Appeal Decision

Appeal Ref: 6006285

4 Daniels Gate, Long Sutton, Spalding, Lincolnshire PE12 9DP

- The appeal is made under section 78 of the Town and Country Planning Act 1990 (as amended) against a refusal to grant planning permission.
 - The appeal is made by Mr and Mrs Lockyer against the decision of South Holland District Council.
 - The application Ref is H11-1009-25.
 - The development proposed is sunroom extension.
-

DRAWING TITLE
EXISTING & PROPOSED
PLANS AND ELEVATIONS

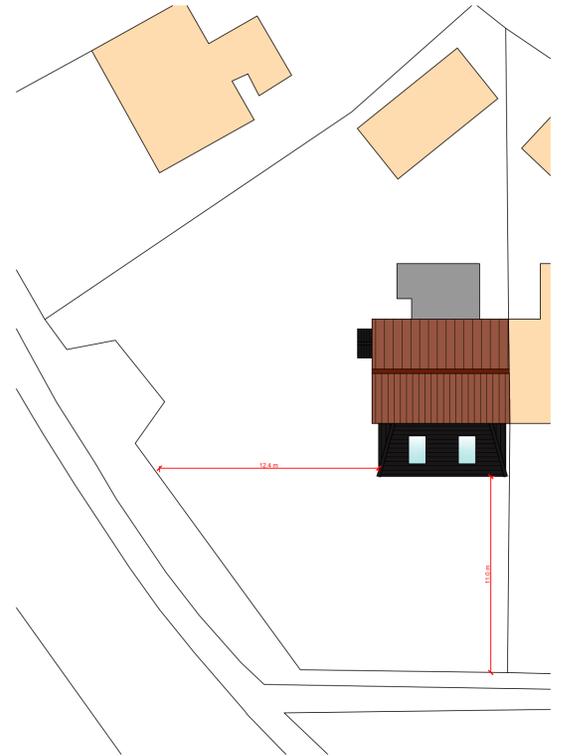
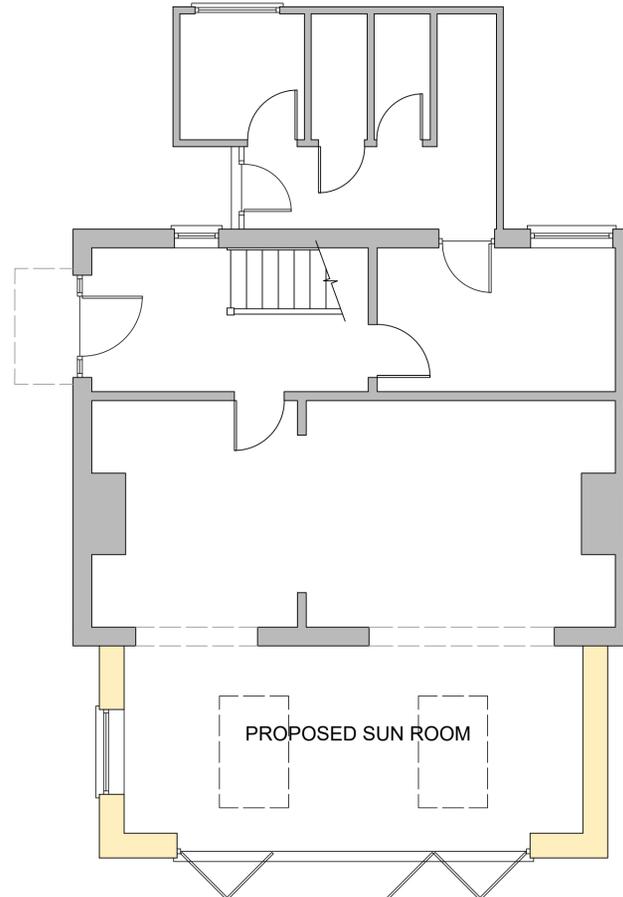
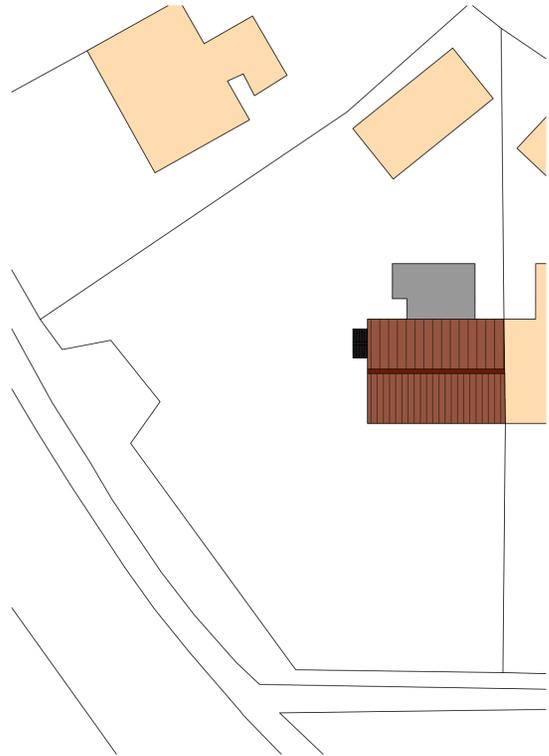
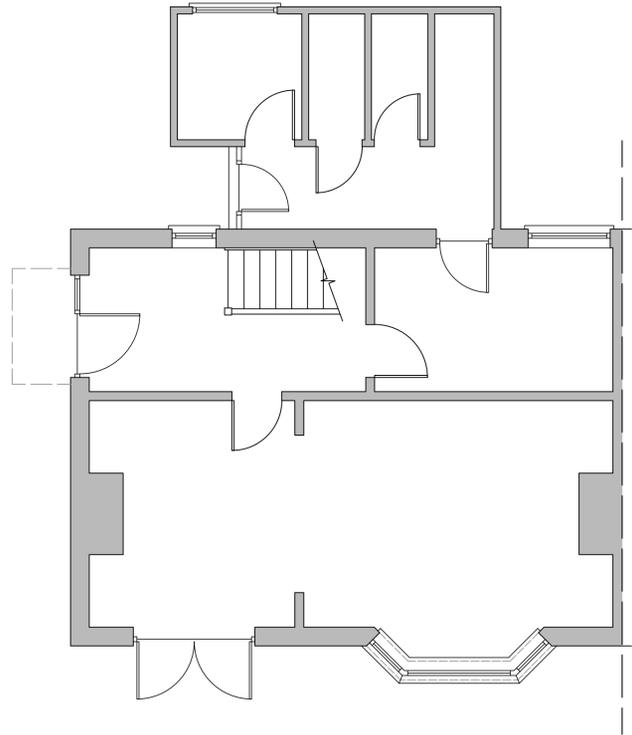
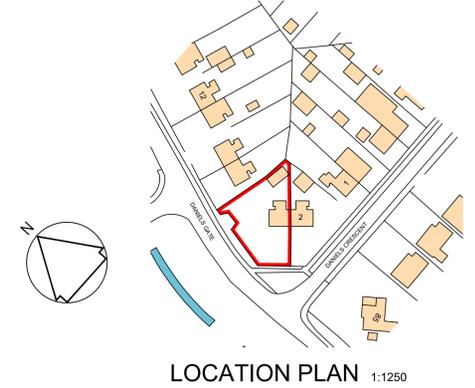
4. The proposal is for a single storey front facing sunroom that would stretch across most of the property's width and would be substantial in depth.
5. The introduction of a significant amount and depth of built form, forward of the principal elevation of the property, would be at significant odds with its neighbour and other similar examples along Daniels Gate. It would therefore be an incongruous and overly dominant addition to the front of the property.

6. Whilst the plot is currently bound by a substantial front hedgerow boundary that largely precludes views into the site from Daniels Gate, the retention and ongoing maintenance of such a feature could not be secured in perpetuity. Therefore, existing or proposed soft landscaping features would not provide effective and enduring mitigation against the harm found.

8. For the above reasons, the proposal would harm the character and appearance of the host property and the surrounding area. Thus, it would be contrary to Policies 2 and 3 of the South East Lincolnshire Local Plan (2019), which, amongst other things, require development to be of high-quality design, which is appropriate to, and maximises opportunities for improving, the character and appearance of the local area.
